Project Name: SEVEN BAR RANCH

DEVELOPMENT REVIEW BOARD – SPEED MEMO

DRB CASE NO/PROJECT NO: 1006721

SITE PLAN FOR BUILDING PERMIT
SITE PLAN FOR SUBDIVISION

1 SITE PLAN APD 6th Area Command Scale: 1" = 30'-0"

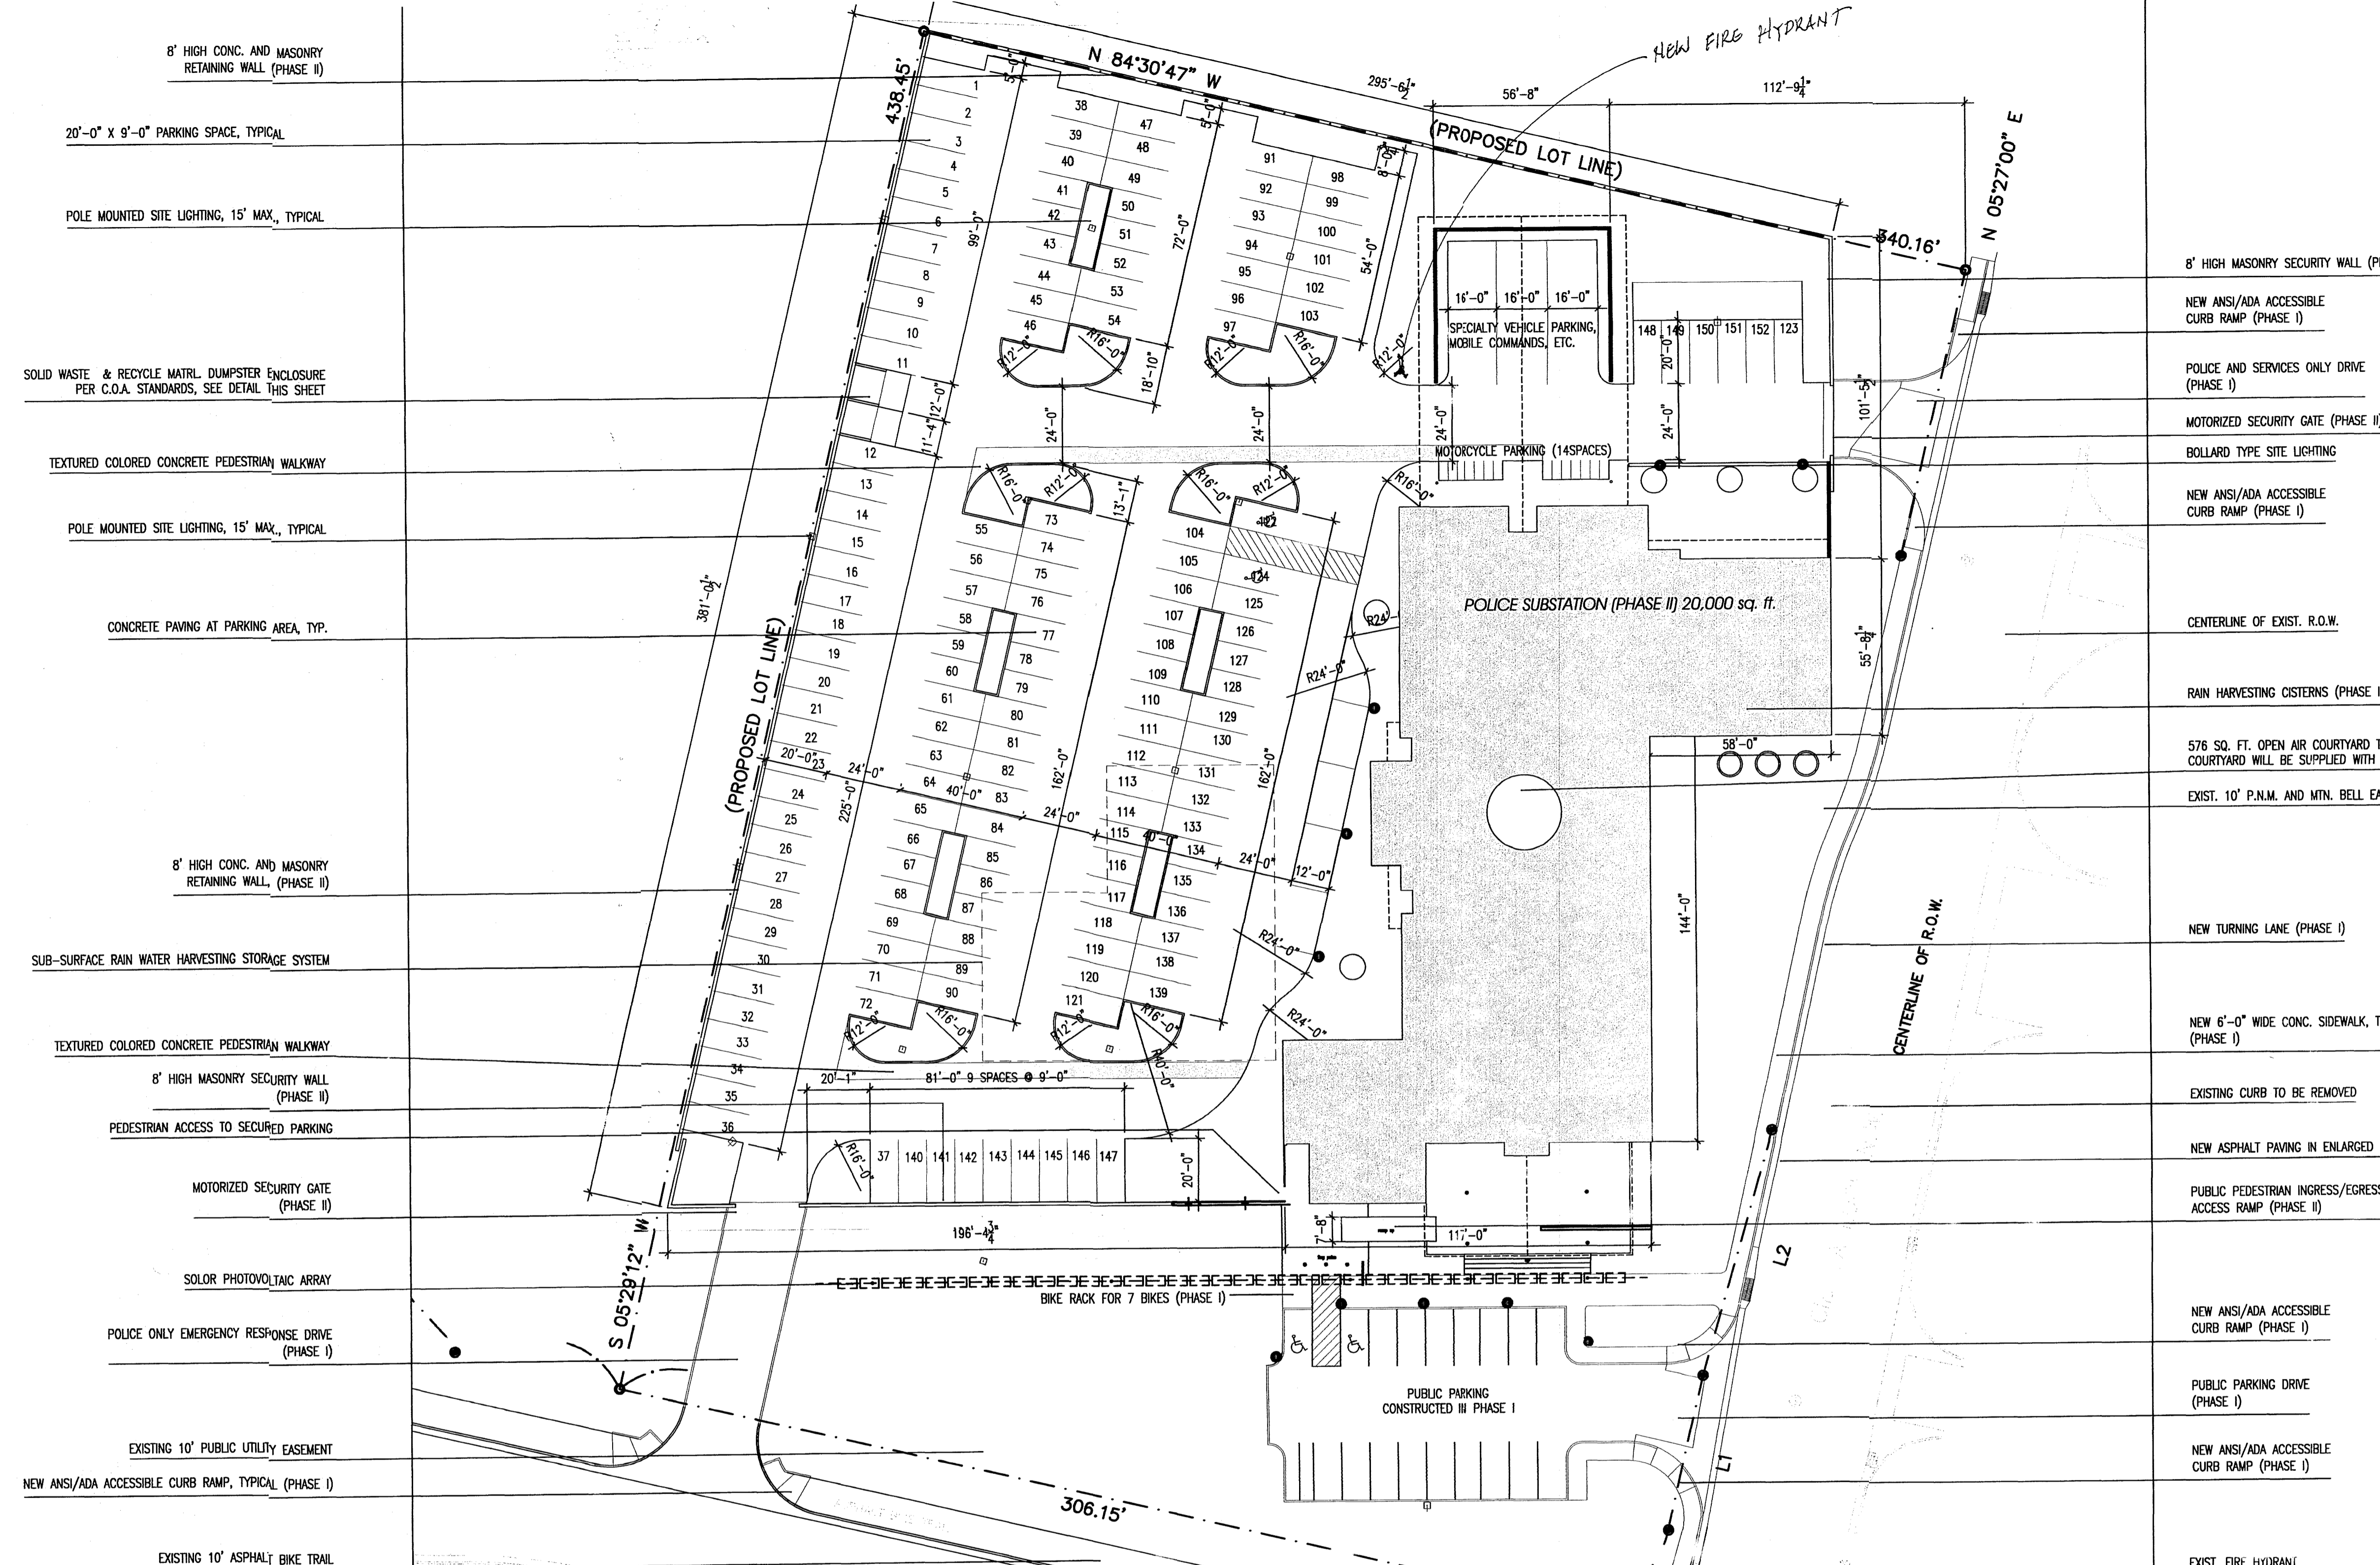
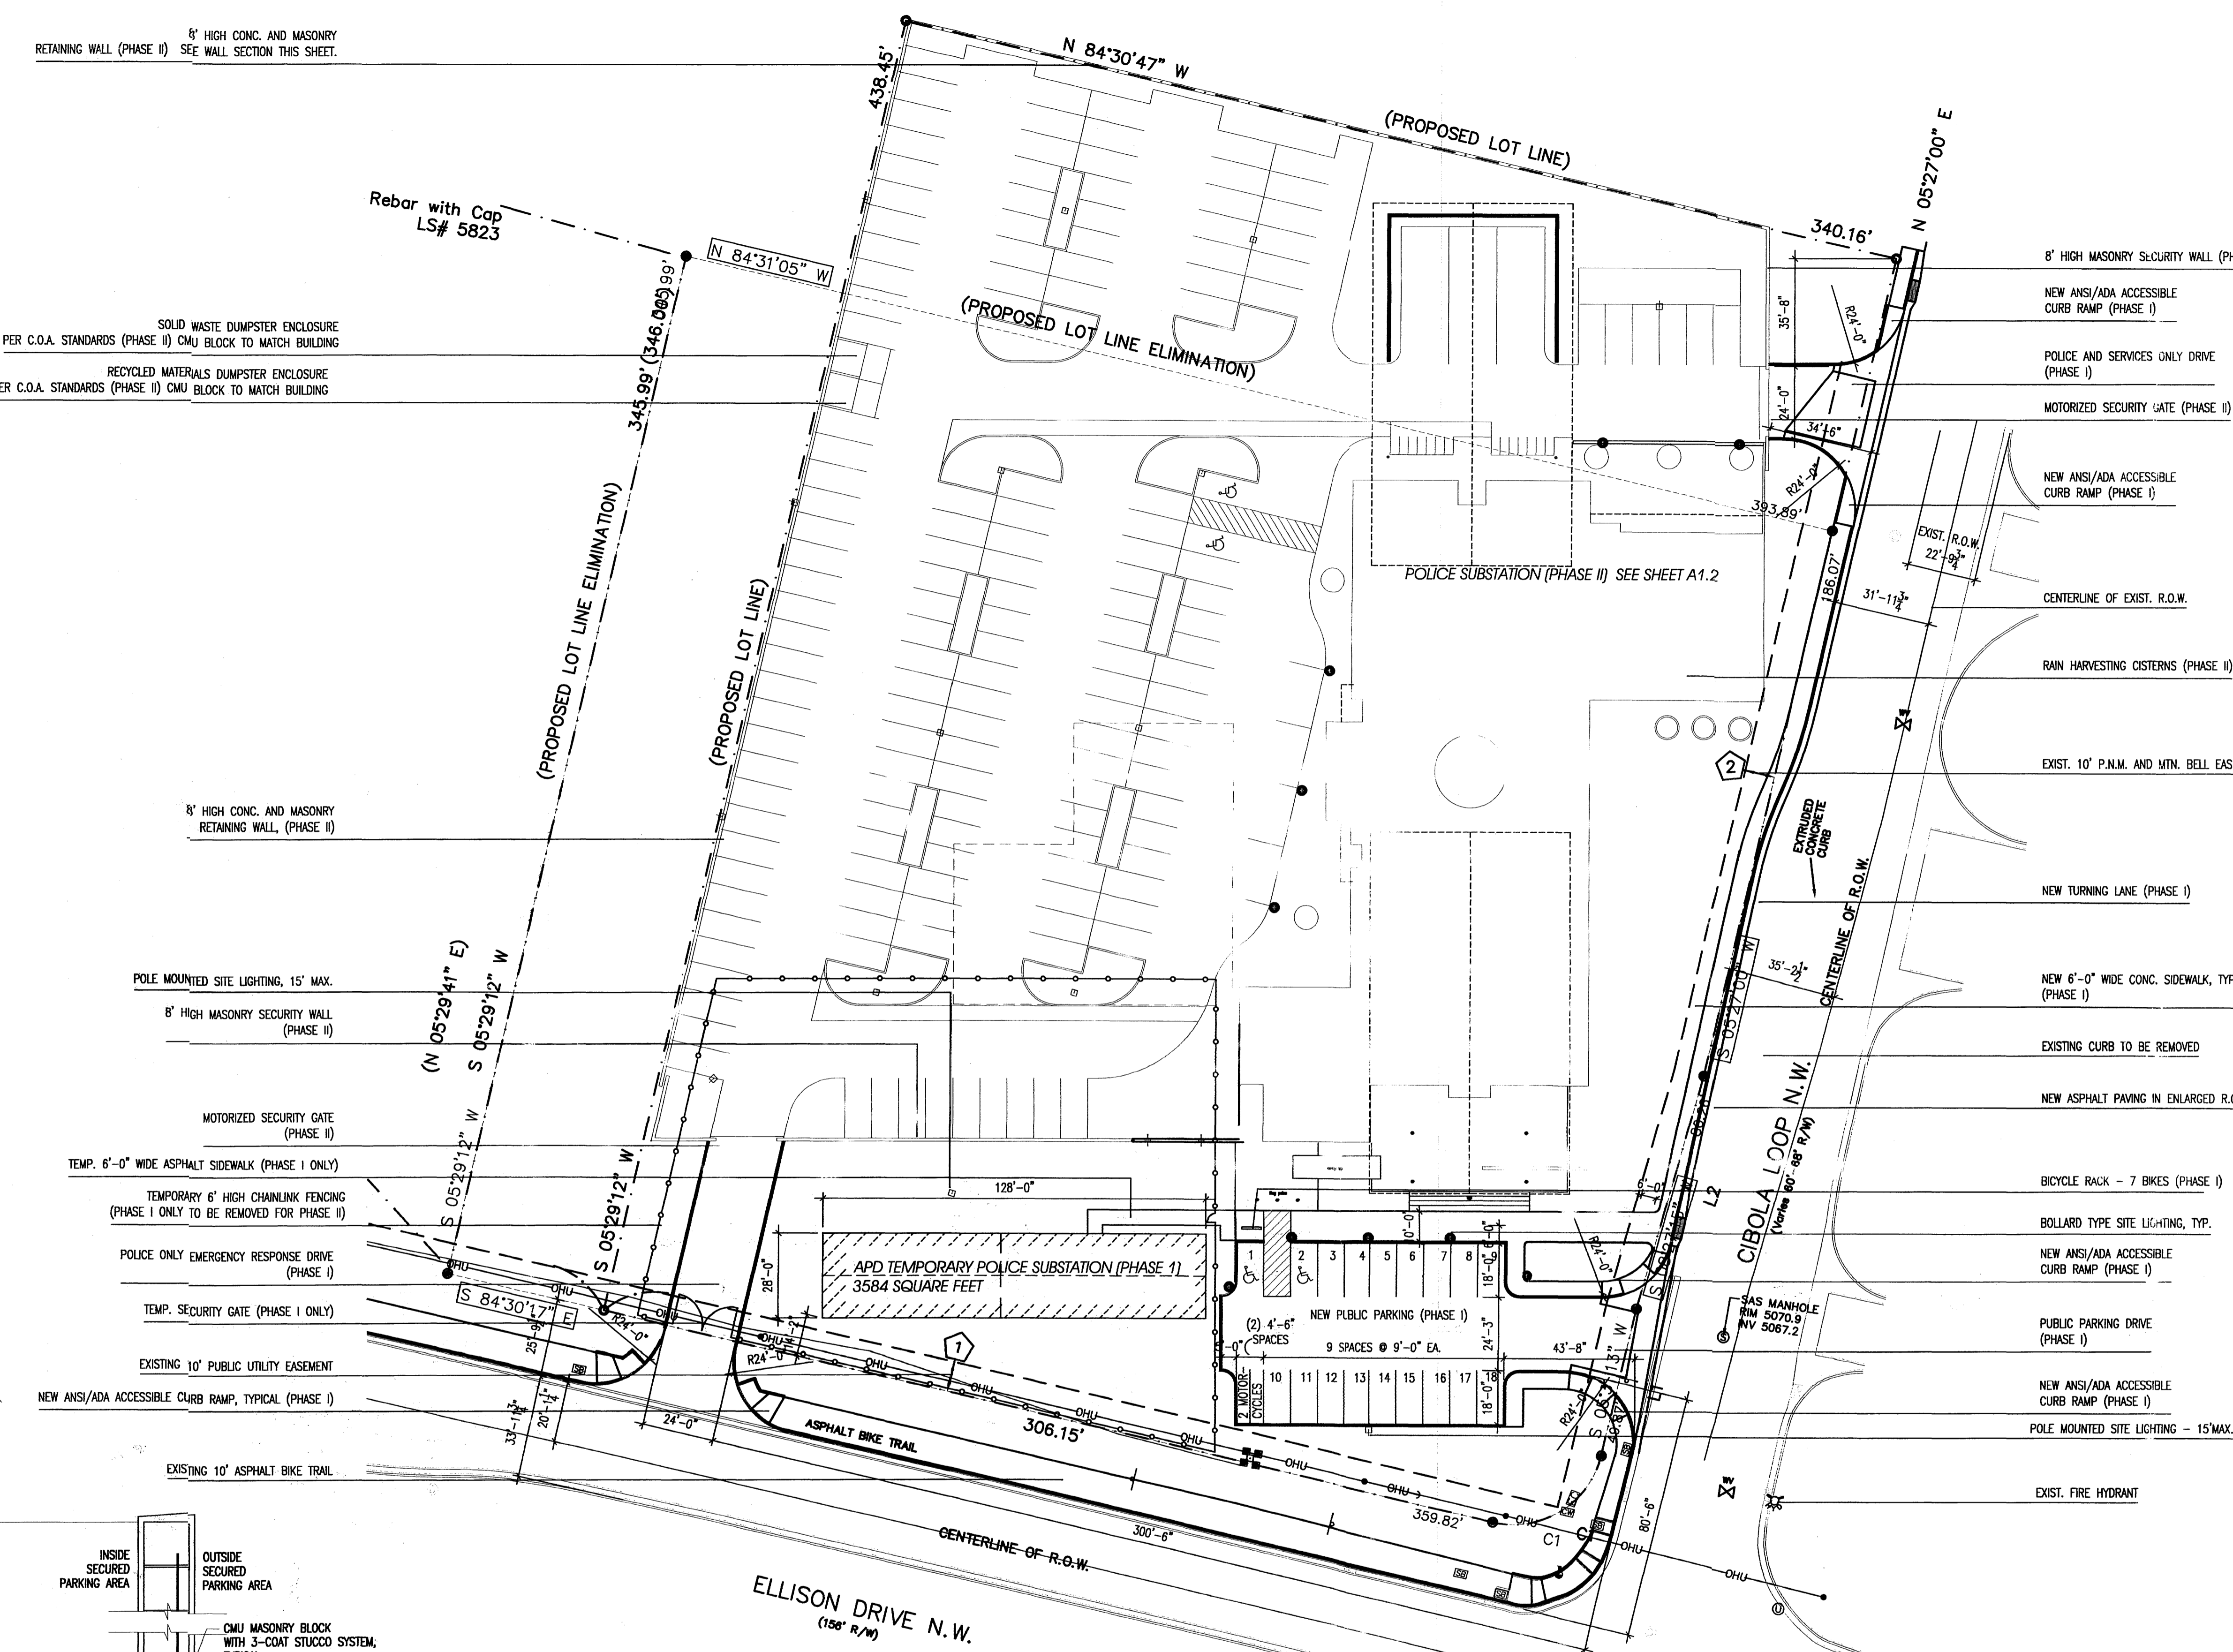
- Wheelchair ramps are not entirely located within the right of way; a sidewalk easement will be required
- Keyed notes not defined; if this is meant to indicate an existing easement, the recording information must be provided
- Public sidewalk located outside of the right of way will require a sidewalk easement
